From: Amanda Scholes on behalf of Planning.Responses
Sent: 04 July 2017 08:33
To: Planning Scanning
Subject: FW: Planning Consultation on LU/177/17/DOC

I would like to make the following comments in respect of the details submitted in connection with condition 10, 14 and 15 of planning application LU/314/16/PL:

APPLICATION LU/177/17/DOC
NO:

Description of Works: Application for approval of details reserved by condition imposed under planning permission LU/314/16/PL relating to condition No. 3 (Landscaping scheme), 4 (Habitat mitigation strategy), 6 (Foul & Surface water sewerage disposal), 10 (Details of plant & equipment), 14 (Details of kitchen extract system & type of cooking to be undertaken in the facility) & 15 (External lightings scheme)

Standard Extract Canopy

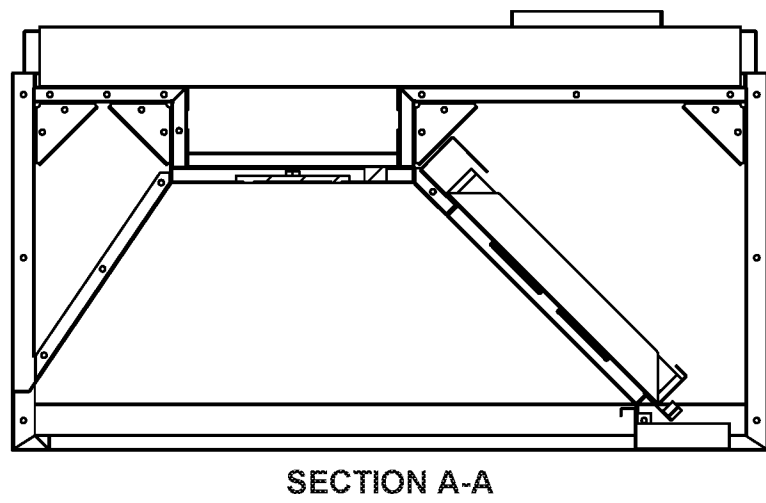
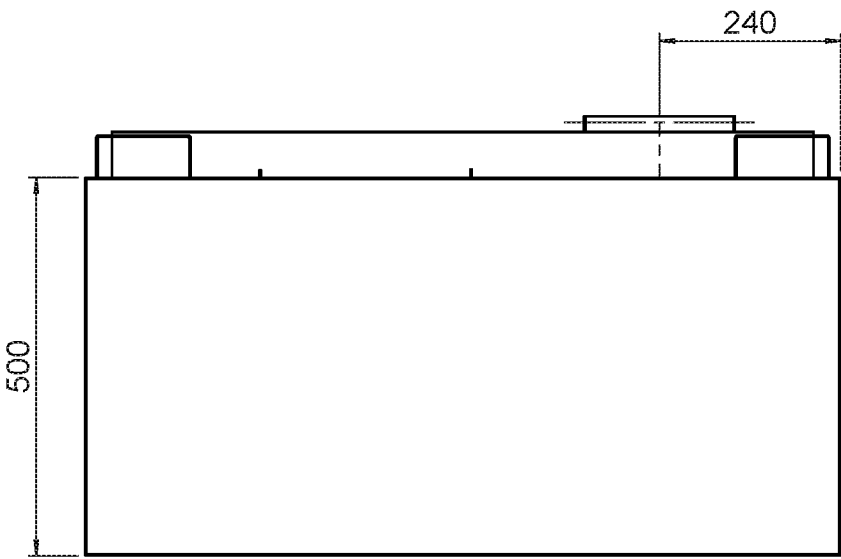
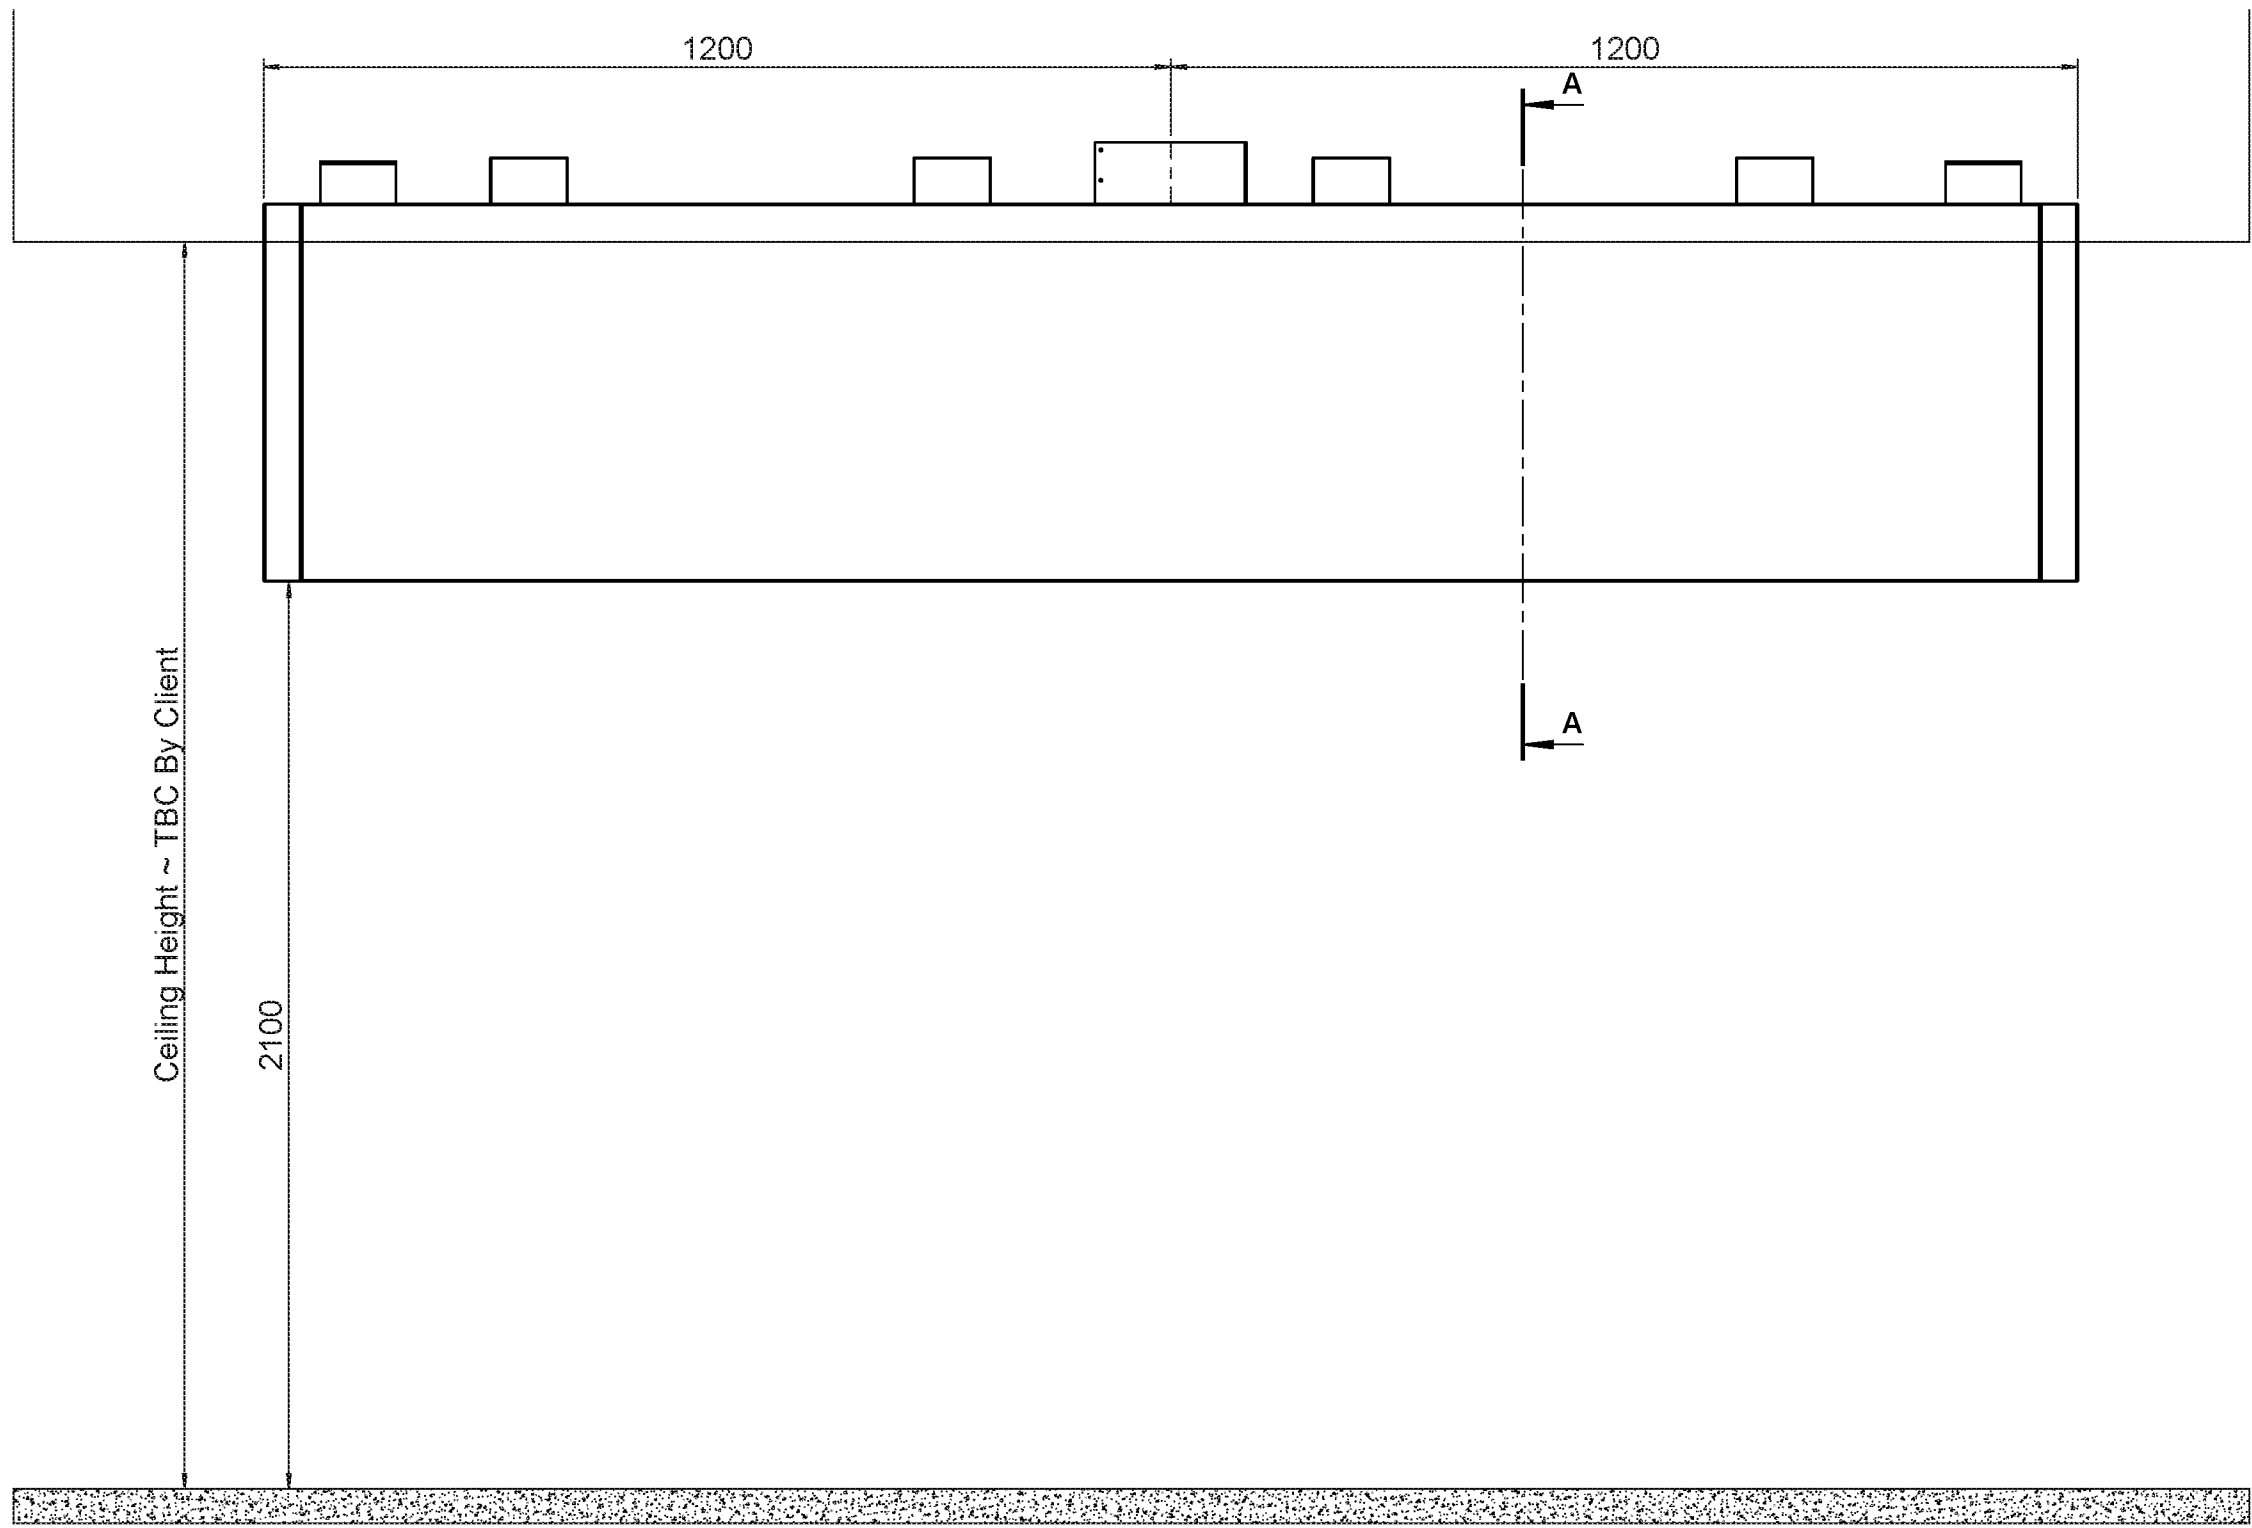
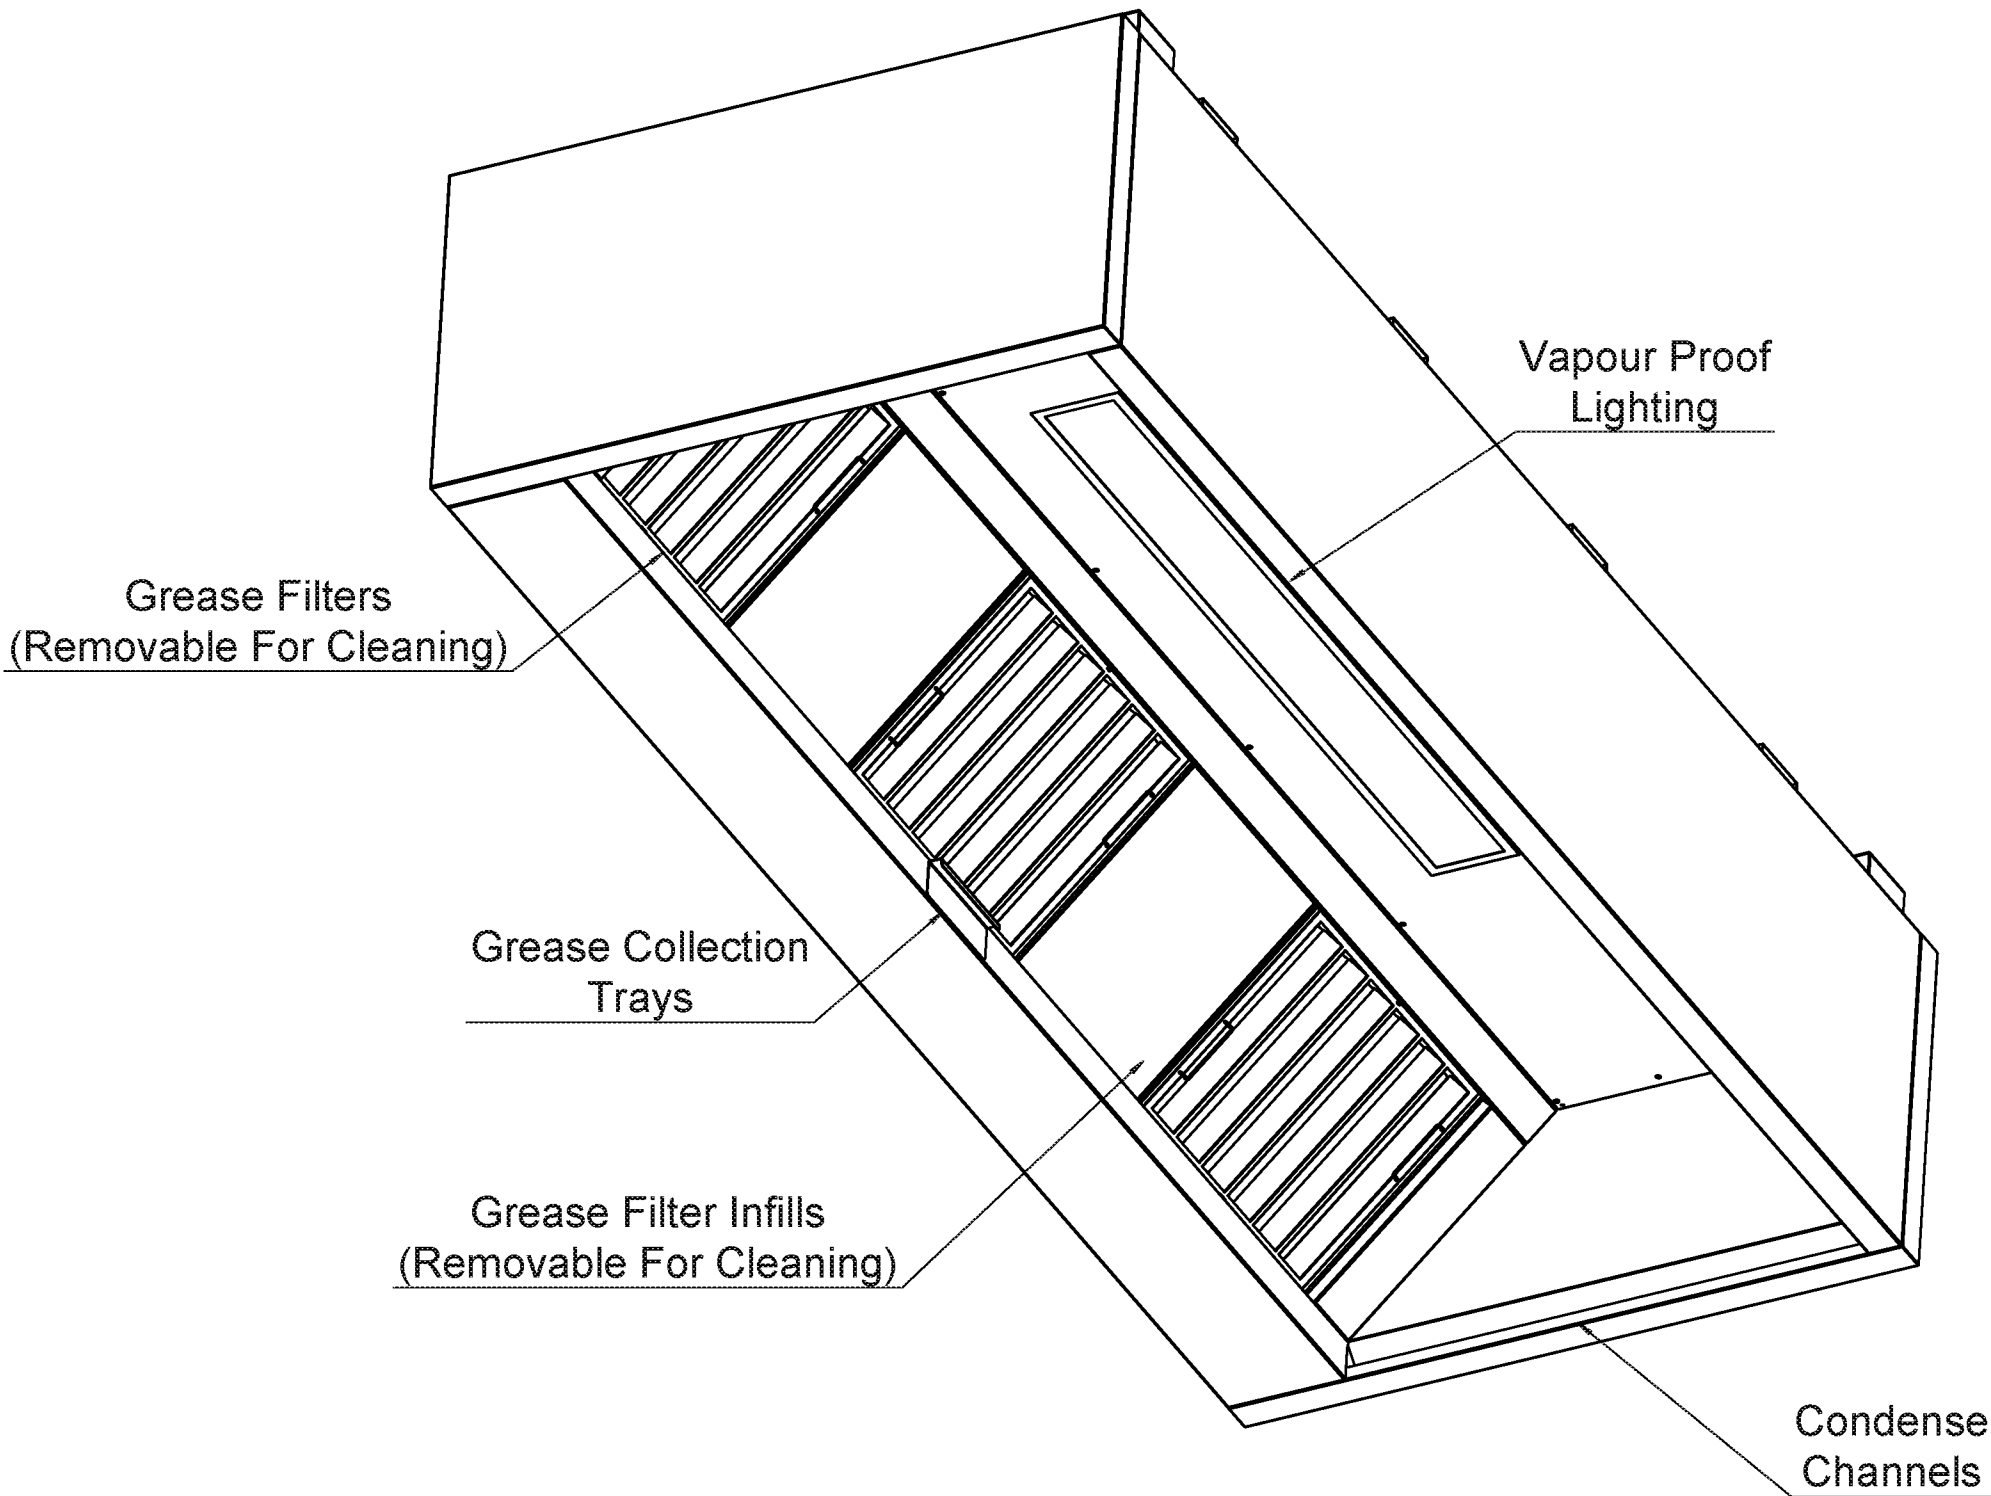
The information provided in the statement from Wilmott Dixon, dated 30 May 2017 indicates that only a very basic level of catering will be provided and as such the odour generation is likely to be minimal. As such I am satisfied with the proposals and that this condition can be discharged.
